Ms Poonam Chauhan
Development Manager
UNIT 4 161
REDFERN STREET
REDFERN NSW 2016

**Doran Drive Plaza Precinct (SSD-15882721)
Response to Submissions Report**

Attachment A

166sqm Solar Access to 25% of Principle usable part of Private Open Space 646sqm (25%)

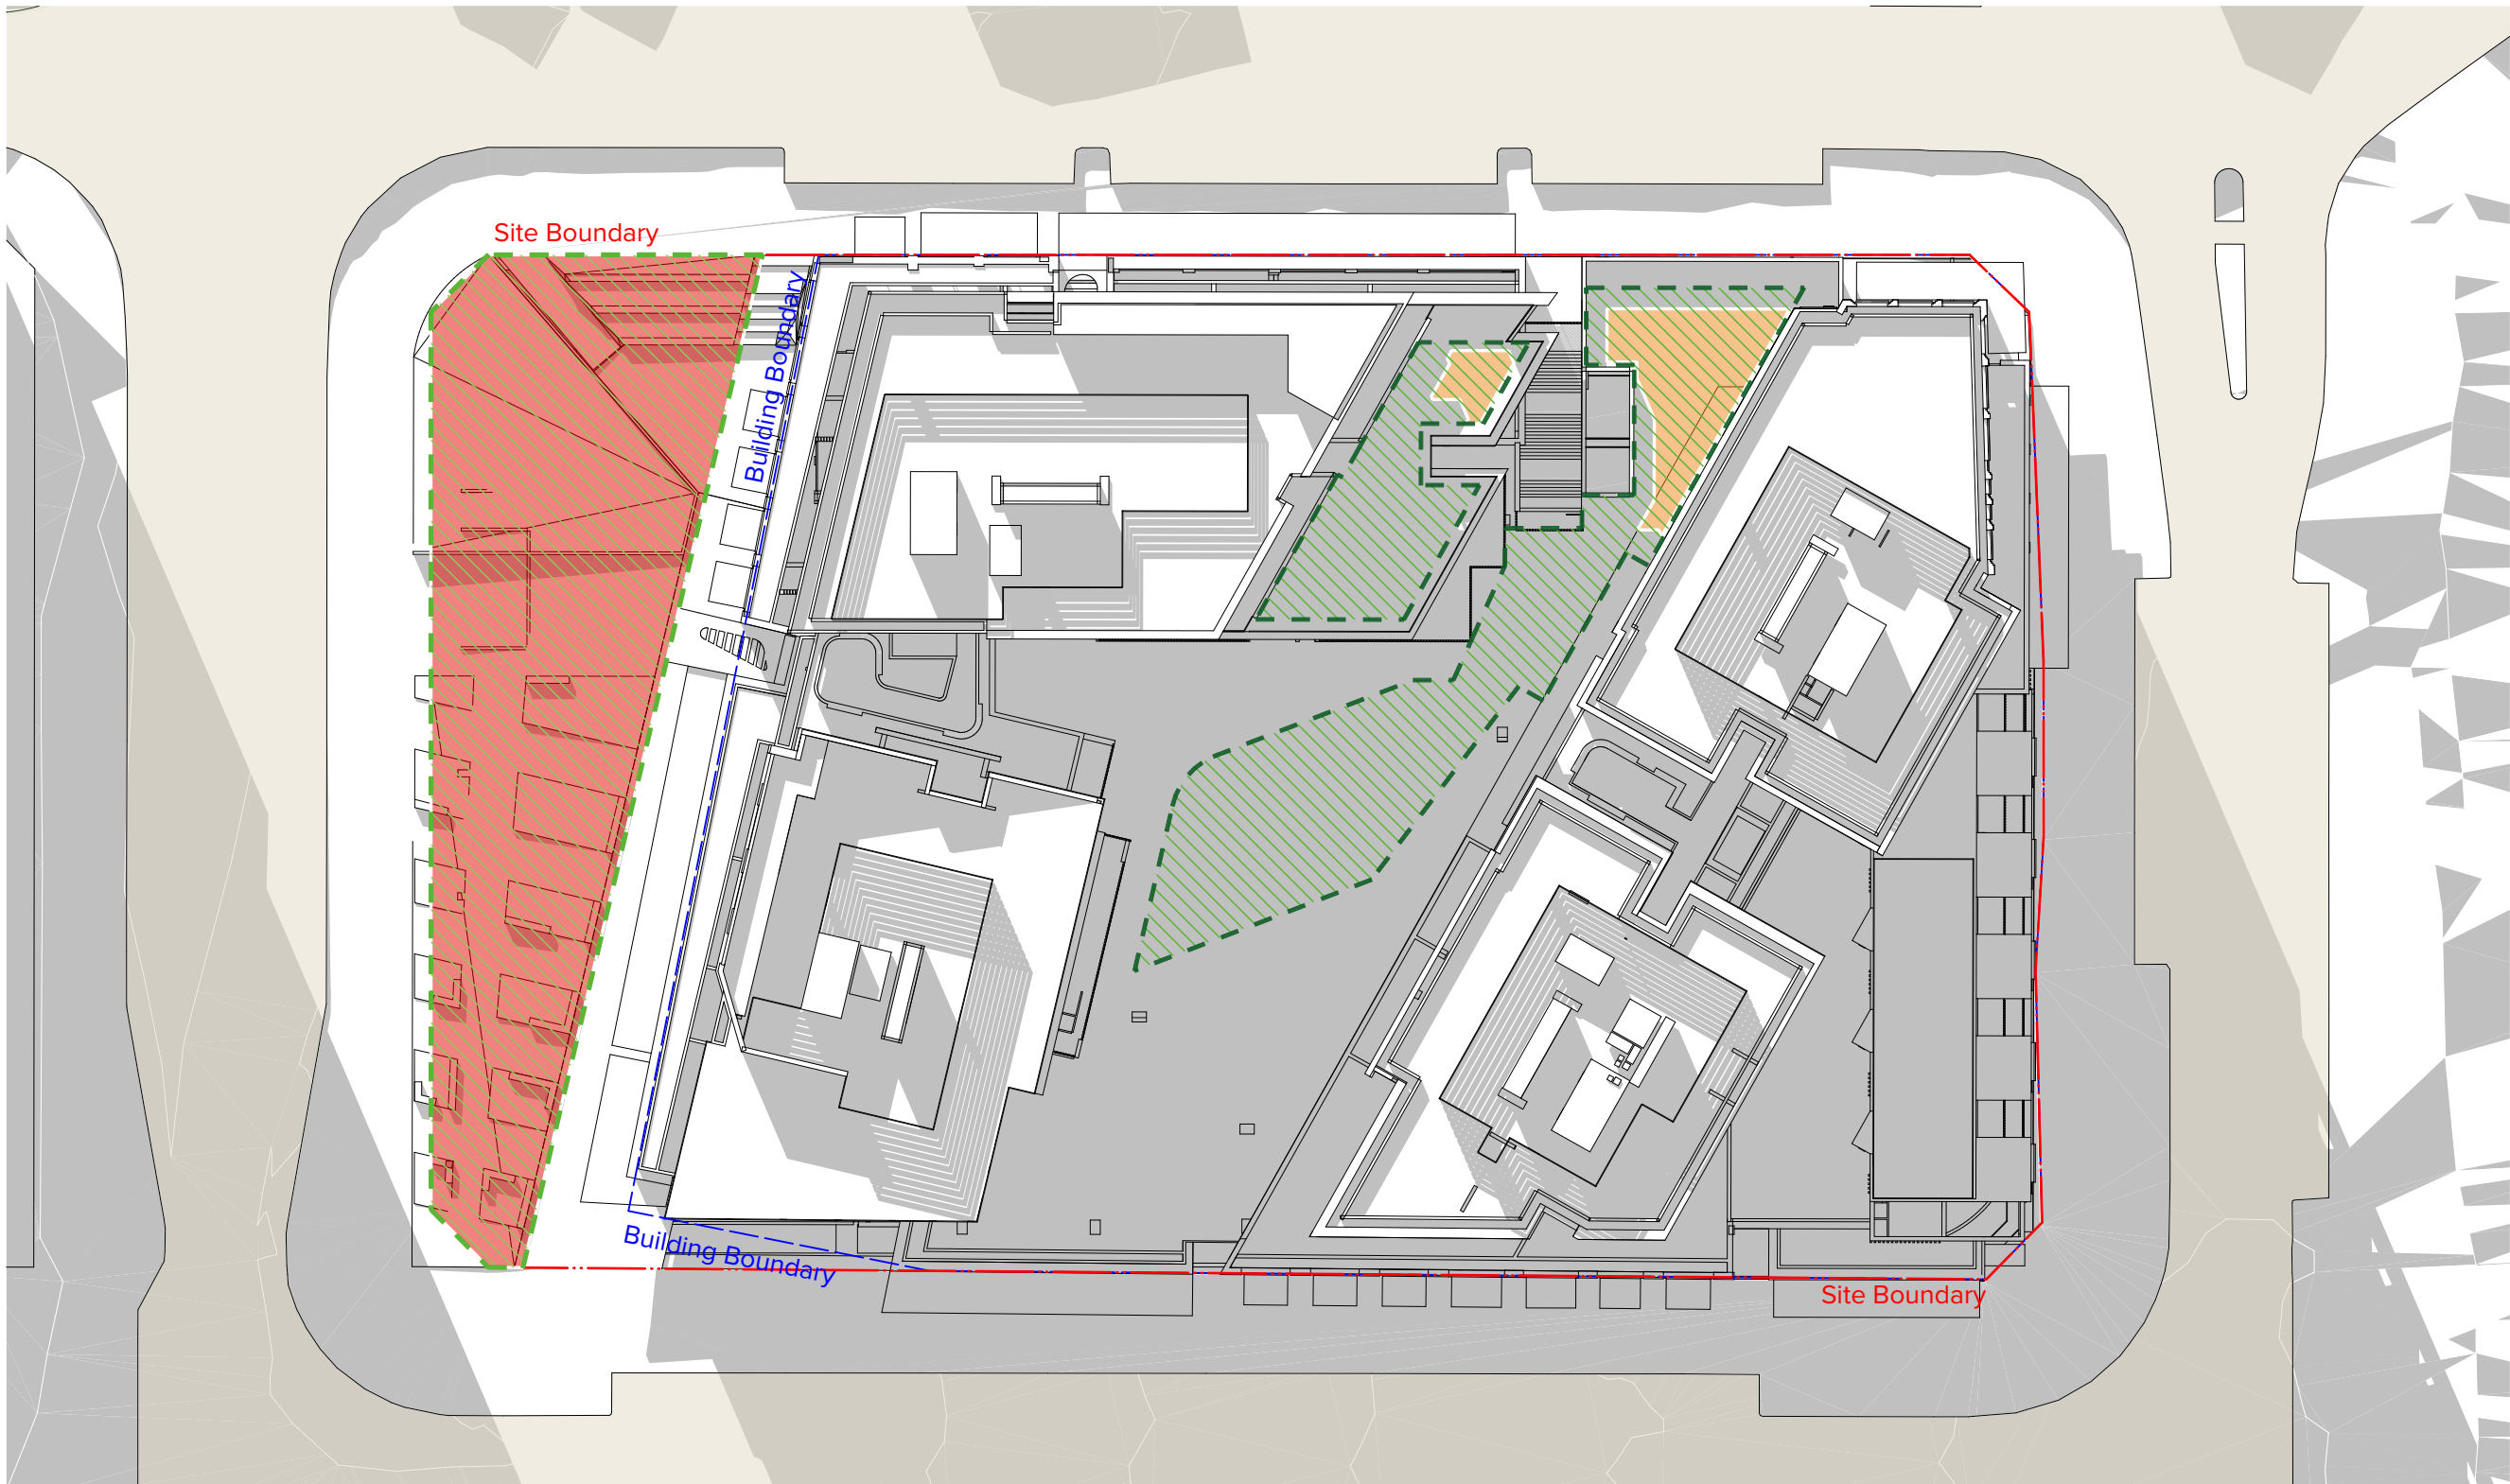
- a) Review and amend the proposal to meet the Apartment Design Guide (ADG) requirements for:
 - minimum solar access to apartments
 - communal open space, in terms of quantity identified as usable area and minimum solar access
